Your Reference: EN010083
Our reference: DCO/2018/00017

17 June 2020

**APPLICATION BY WT/EFW HOLDINGS LTD FOR AN ORDER GRANTING
DEVELOPMENT CONSENT FOR THE WHEELABRATOR KEMSLEY (K3)
GENERATING STATION AND THE WHEELABRATOR KEMSLEY NORTH (WKN)
WASTE TO ENERGY FACILITY**

Marine Management Organisation Deadline 5 Response

- Legend**
- Order Limits
 - Works Area 1 Limits
 - Works Area 1A Limits
 - Works Area 1B Limits
 - Works Area 1C Limits
 - Works Area 1D Limits
 - Works Area 1E Limits

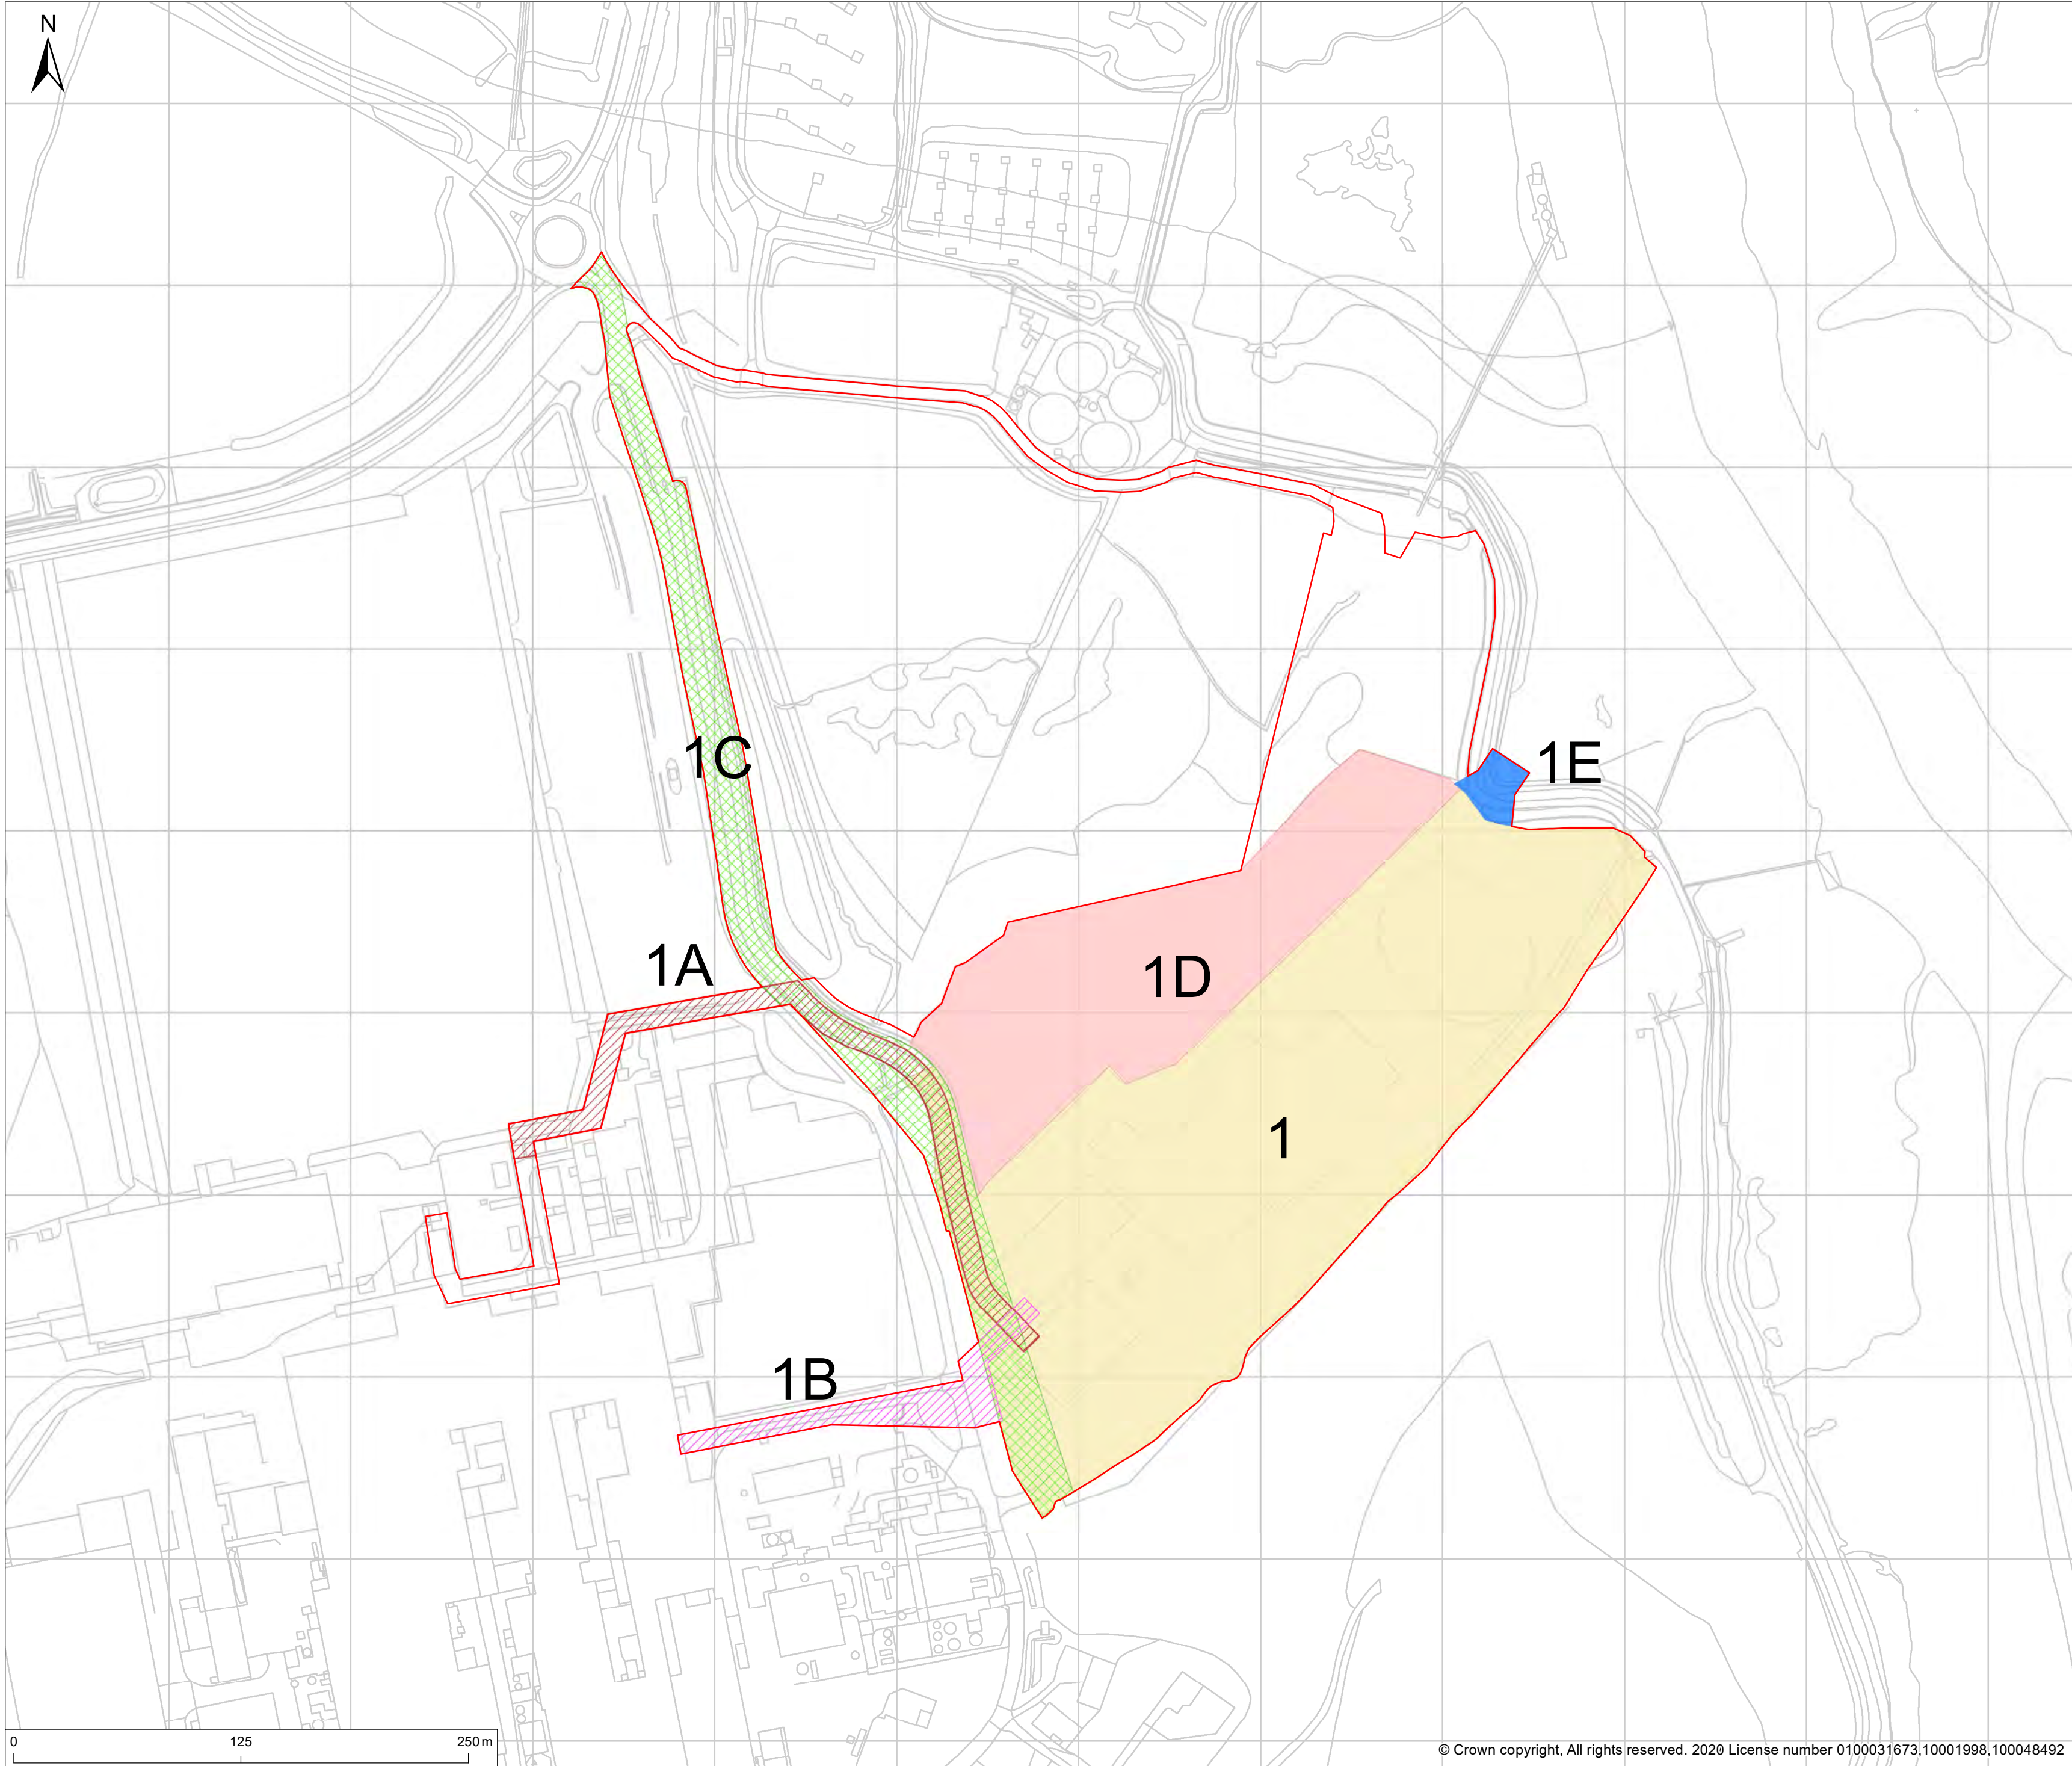
2.18. With regard to Work No 1E *"Construction and operation of a surface water outfall for Work No 1"*. The MMO request further clarification on the current status of these works. If these works have been completed and are consented under the existing marine licence, then they should not be included within this DCO. This is a duplication of consent. Similarly, regarding Work No 7 *"Construction and operation of a new surface water outfall for Work No 2"*. The MMO query if this should be included within the DCO as the applicant already has a marine licence consenting this activity.
